**KIRKLEES METROPOLITAN COUNCIL
INVESTMENT & REGENERATION SERVICE**

**DELEGATED DECISION FOR DISCHARGE OF CONDITION -
NOTIFICATION OF A CHANGE OF USE UNDER THE ABOVE
PROVISIONS**

Reference no. 2025/CL/90997/E

**Description Prior notification for change of
use of agricultural buildings to 3
dwellinghouses and associated
operational development**

Title
Proposed Dwelling Three

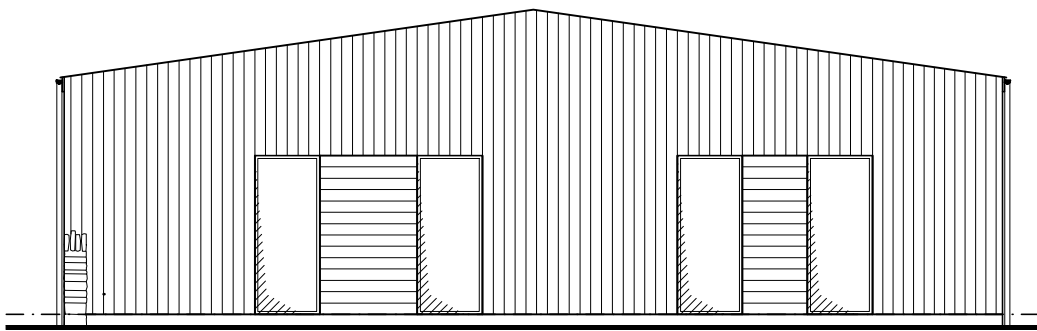
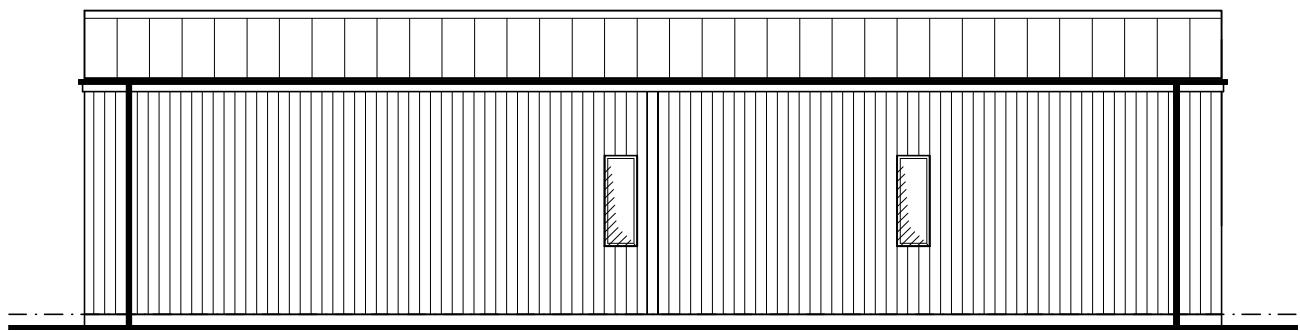
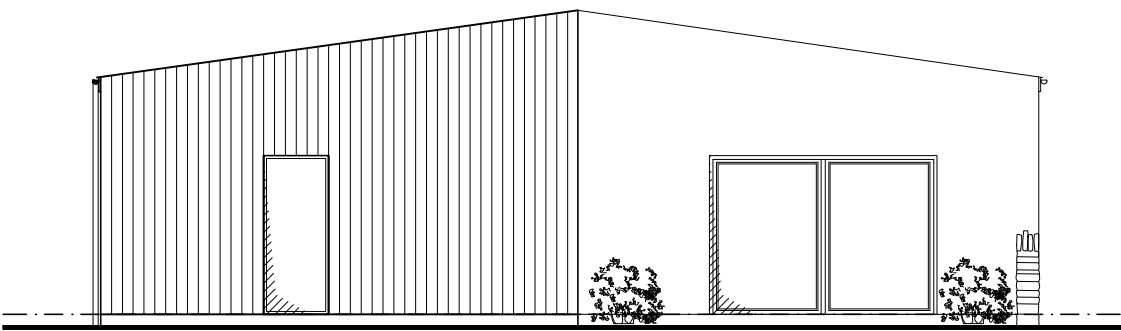
The submitted proposed plans state the that the external walling will be timber cladding and natural stone although the elevational detail seems to indicate

timber boarding on all elevations both for the smaller and larger barn. The roofing materials are stated to be standing seam metal cladding suggesting both buildings would have new roofing.

Overall, it appears from the information provided that all, or at least the vast majority, of the existing external walling and roofing material is to be replaced. It is therefore considered that the buildings as they currently stand, would not be capable to function as converted dwellings without the significant degree of proposed building works. In this case, the proposed works would be considered so extensive as to comprise rebuilding and therefore cannot be considered within the definition of “conversion.”

Title
Proposed Dwelling Two

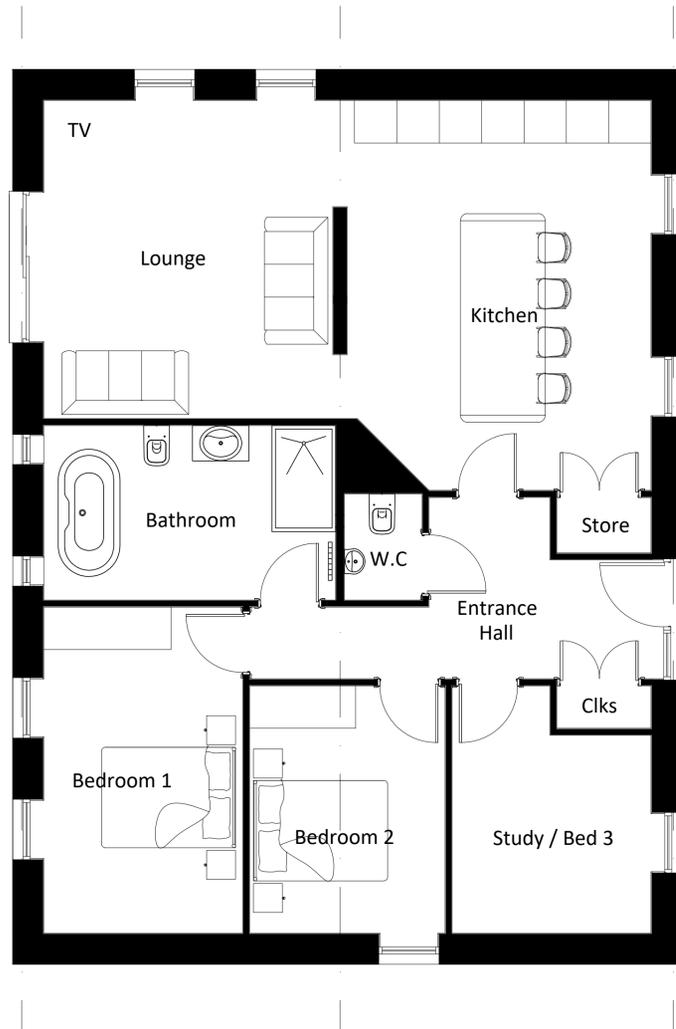
Based on the submitted information, the proposed work to the larger barn would seem to consist of, for plot 2, partial demolition leaving the south and west elevations open requiring new walling and new roof. Works to form plot 1 would require new walling for the east elevation and new roof. The covering letter claims external walling would be retained where they form external walls of the resultant building which appears to suggest the concrete panels and block walling is proposed to be replaced with timber boards and/or natural stone. It is unclear from the information provided whether the existing timber boarding will be retained although it is considered unlikely in light of the detail on the proposed elevations given the existing timber boarding is slatted and unlikely to be suitable to construct a dwellinghouse of “modern build standards and insulation levels”

Title  
Existing Small Barn

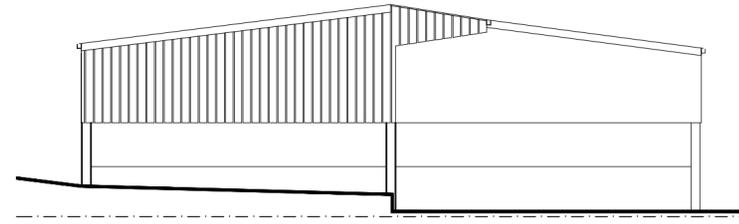
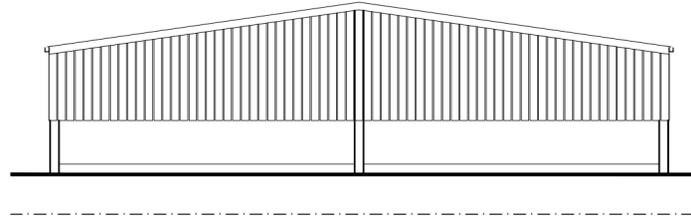
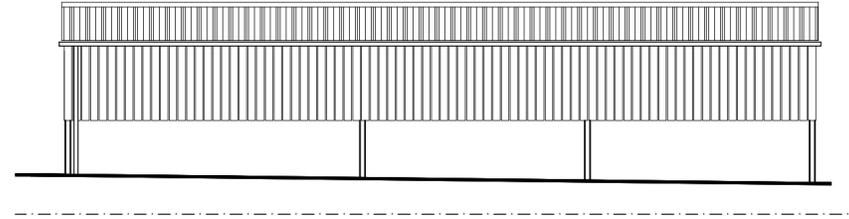
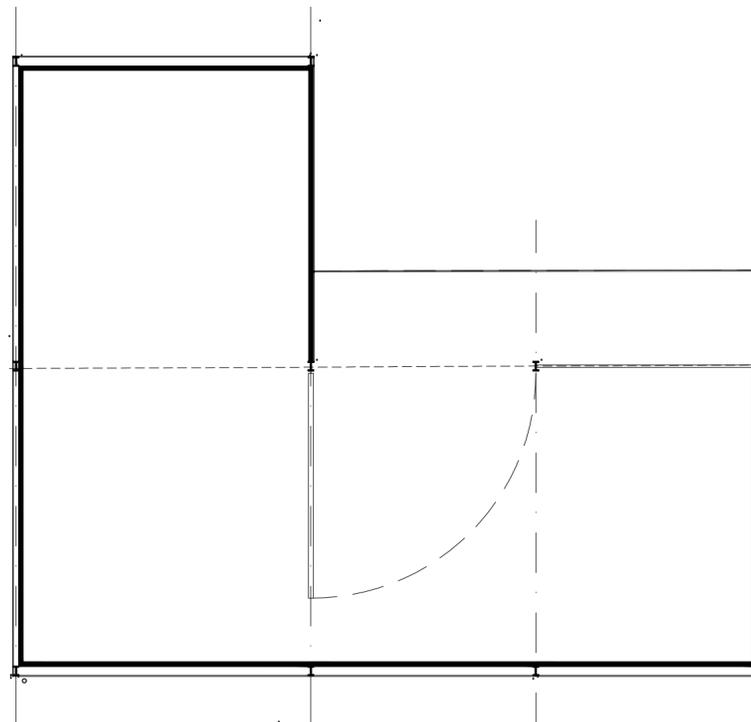
The structural report provides that the portal frame and floor slabs are structurally capable of withstanding the loading of the new roof. The submitted photographs within the structural report show the smaller barn to be constructed from concrete panels/blockwork up to approximately 1.8 metres in height with slatted timber boarding above. The north elevation is currently open along approximately half of the elevation. The larger barn is of similar construction to the smaller barn with some internal block walls at approximately 1.8 metres in height as shown on the existing plans.
